From: Anita Gardner
Sent: 07 May 2019 10:21
To: Planning.Responses
Subject: FW: H.17.37.. Waterbury Specialist Care 03-05-19

Client	Consensus		
Project	Proposed Apartment Development - Waterbury, Ford

Stage - PLANNING

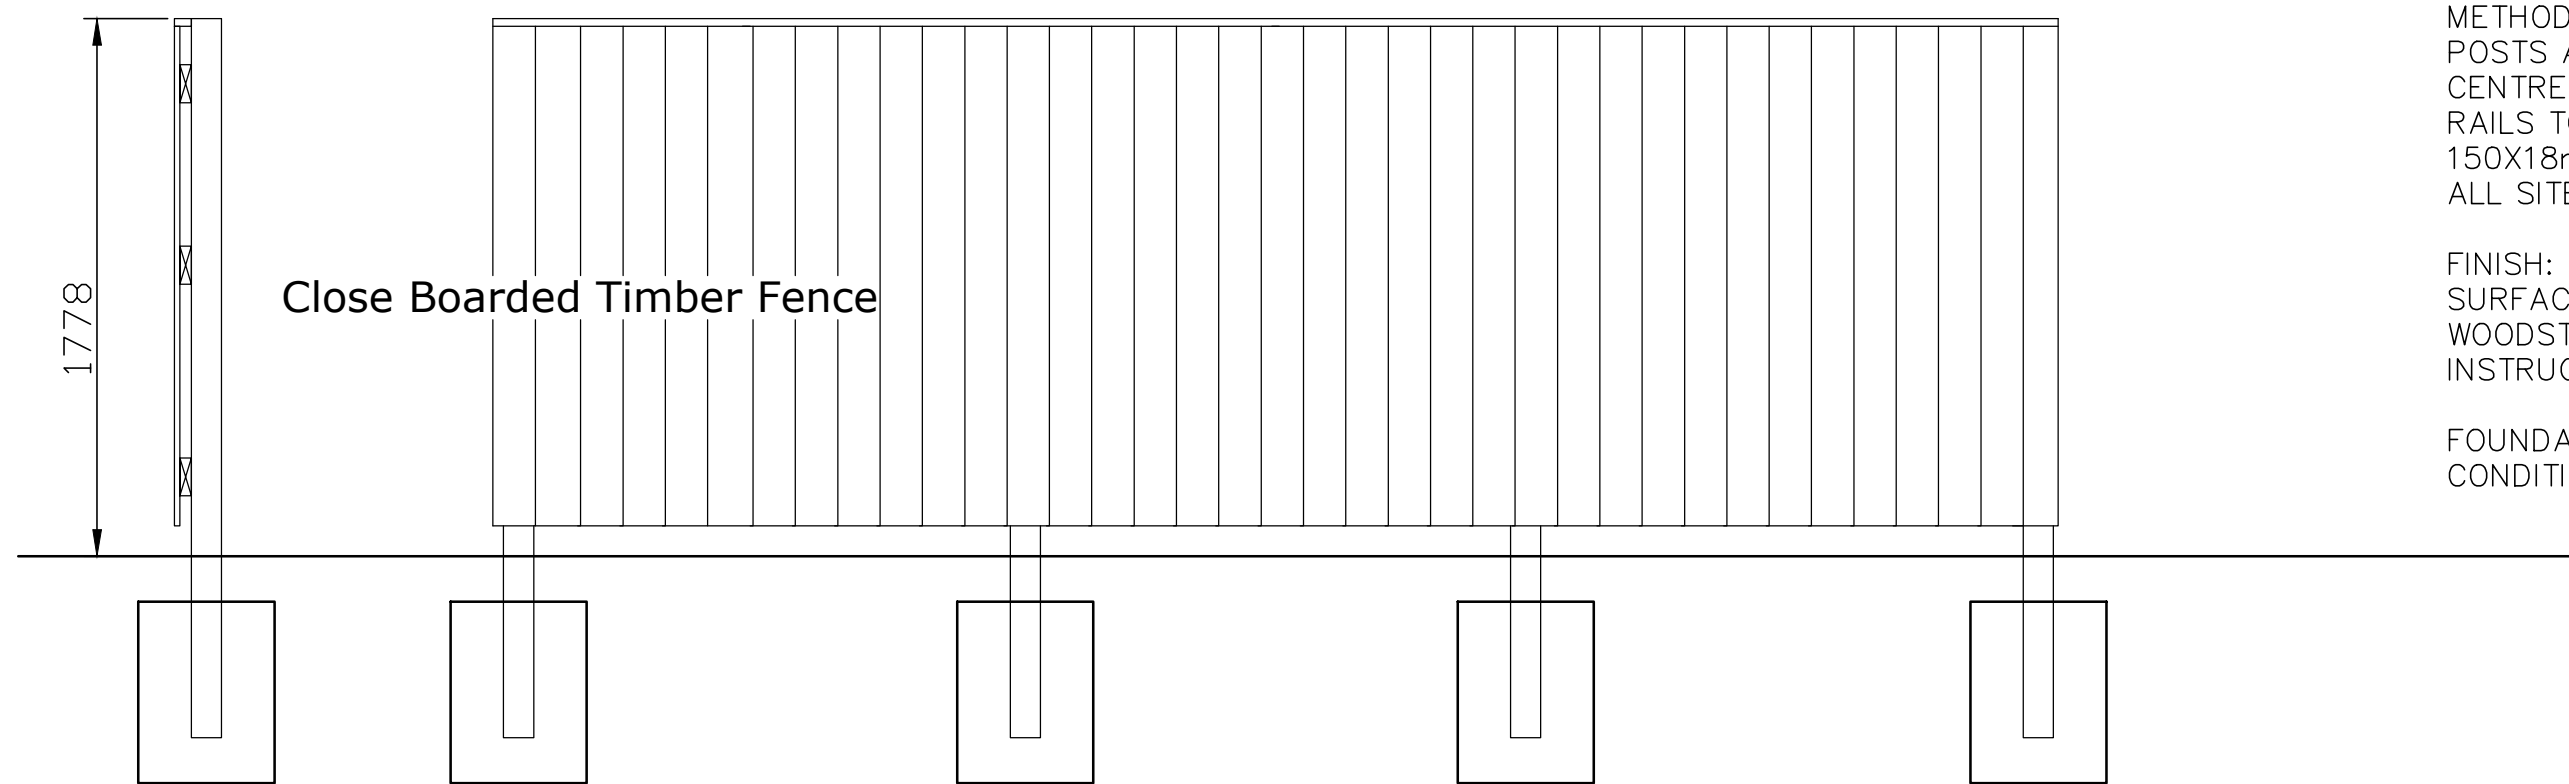
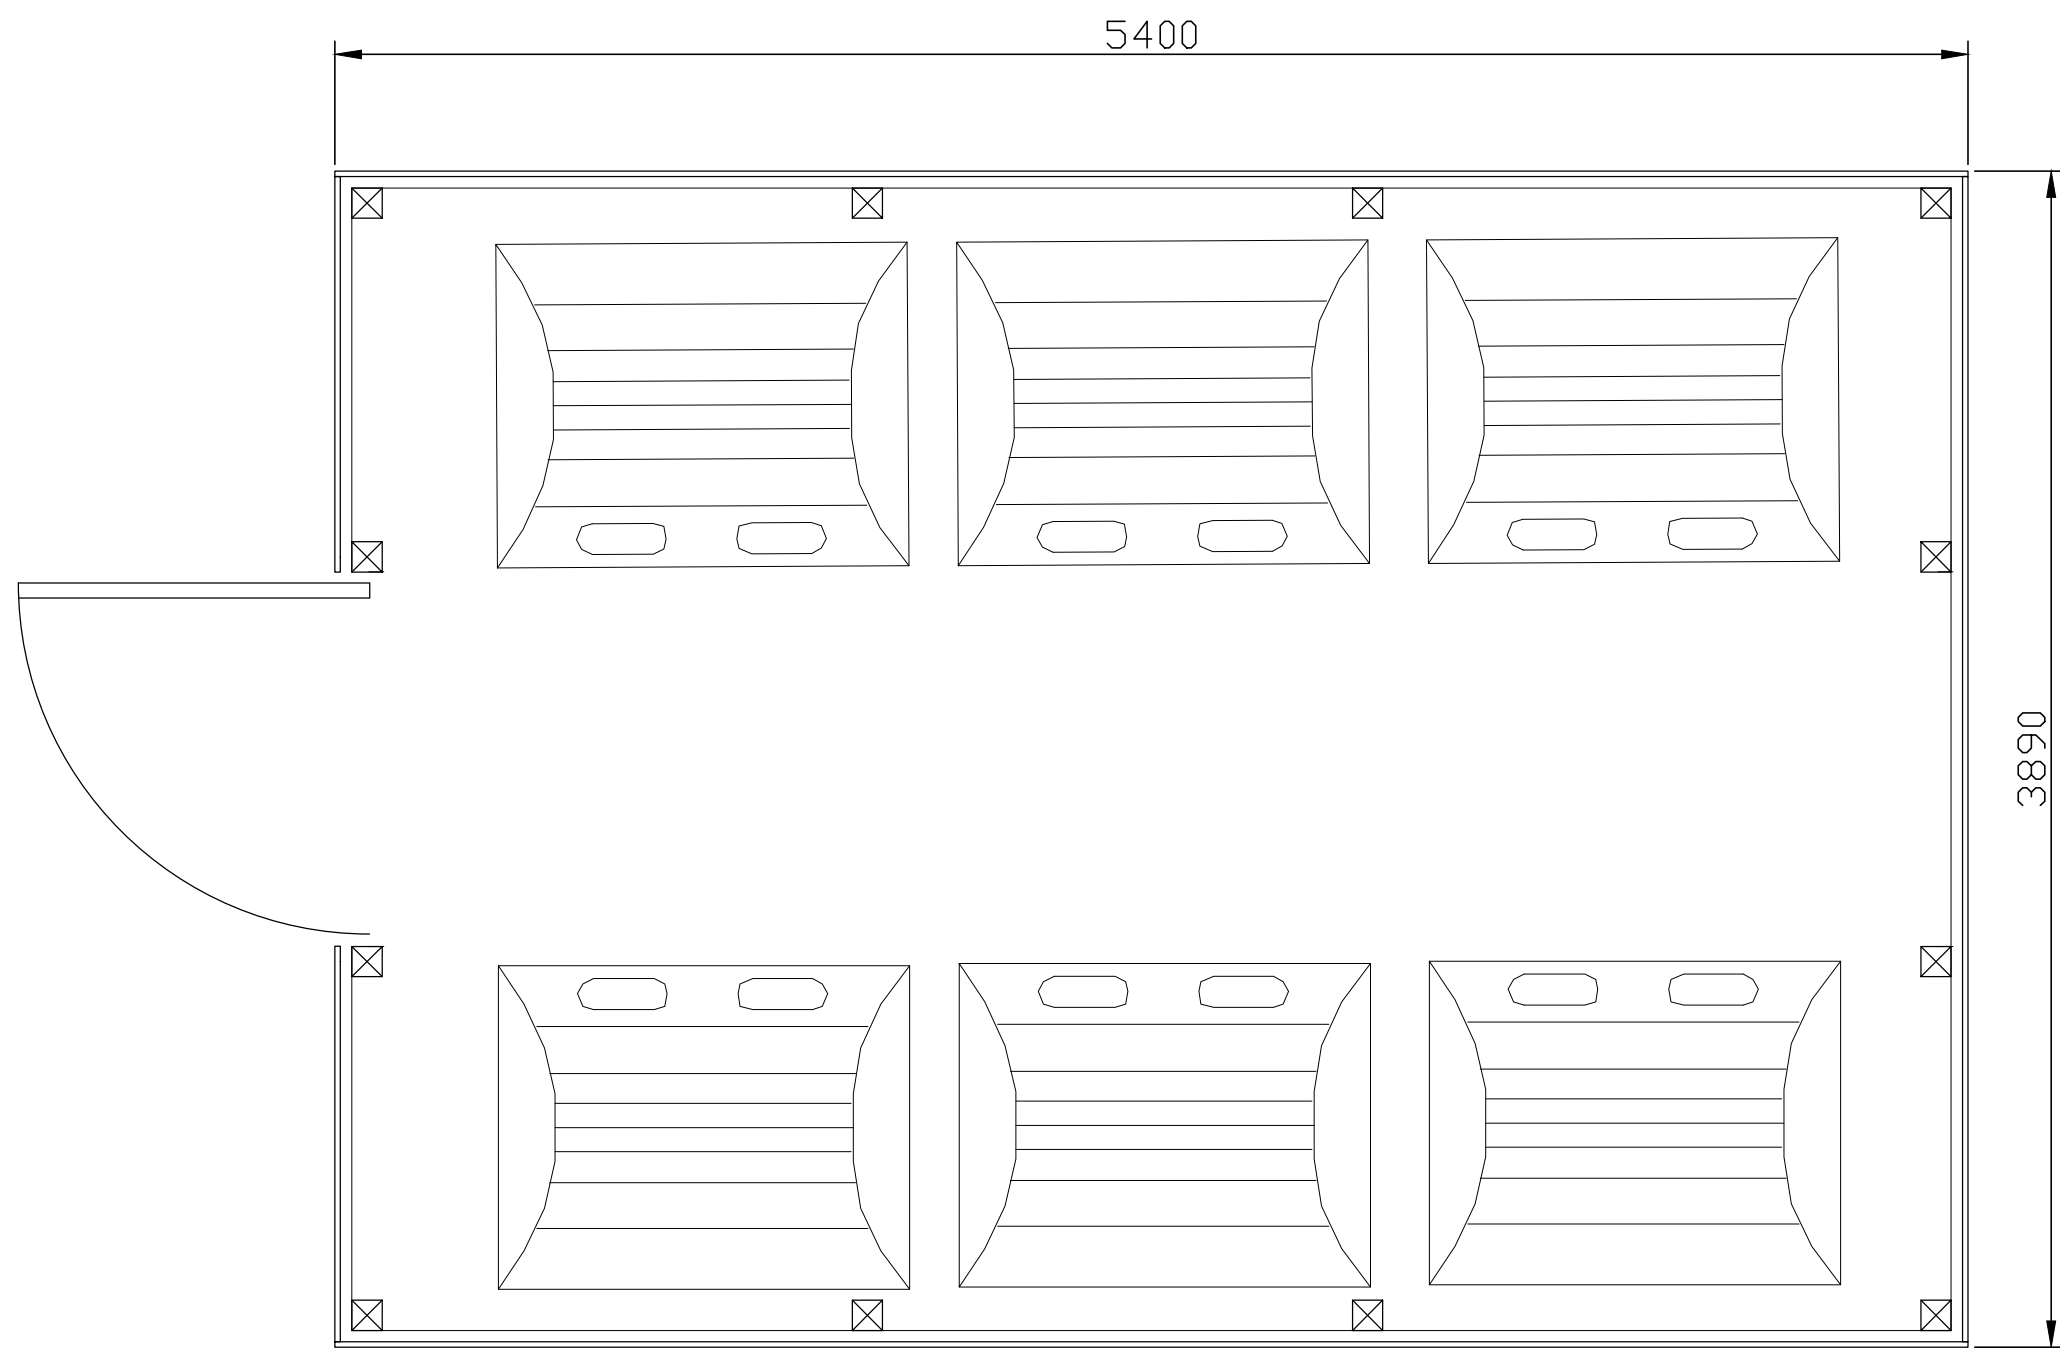
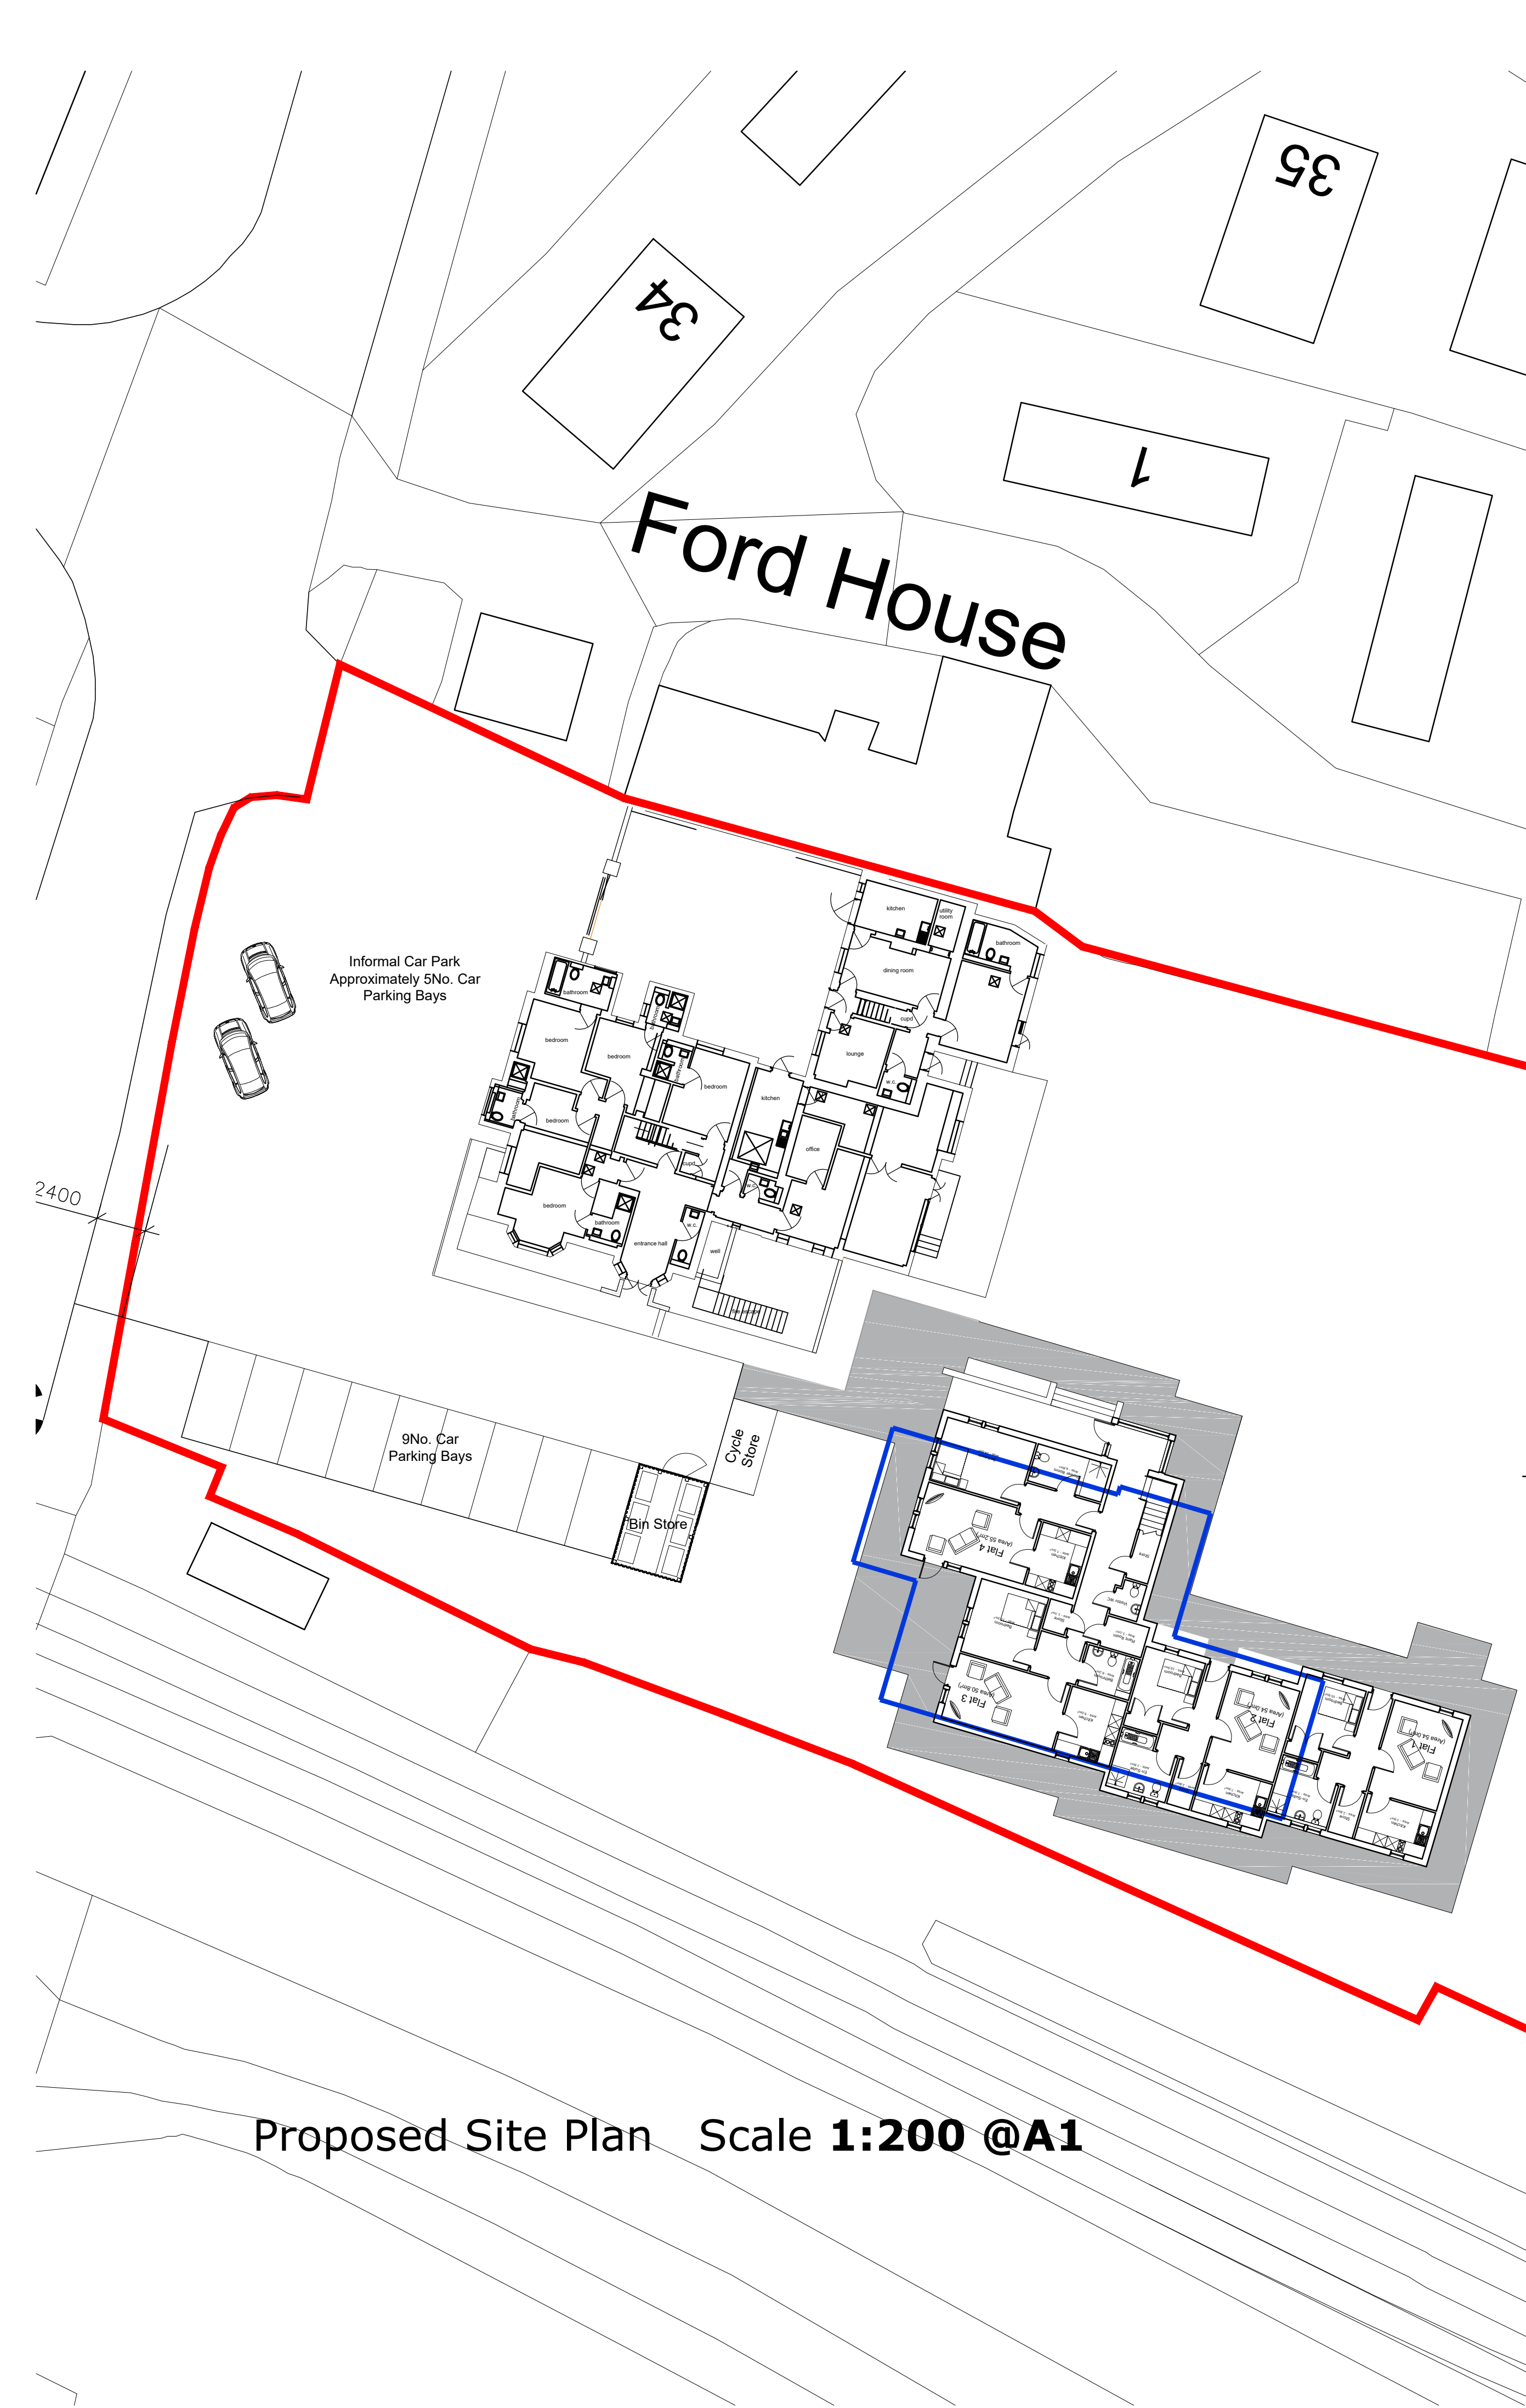
The bin store is 70 inches high and 15.4m long.

My suggestion would be to re-site a smaller bin store to the rear of the site next to the cycle store and have all of the new parking to the front.

I would wish that the applicant provides a plan to support their emails, showing the dimensions of the fencing and showing the maximum achievable visibility splays as a result of this.

Please find attached the updated bin store detail. The existing bin store will be completely removed from the edge of the Highway. I trust this will now be acceptable to Highways, but please let me know if further information is needed.

Please see attached Bin Store proposal as discussed
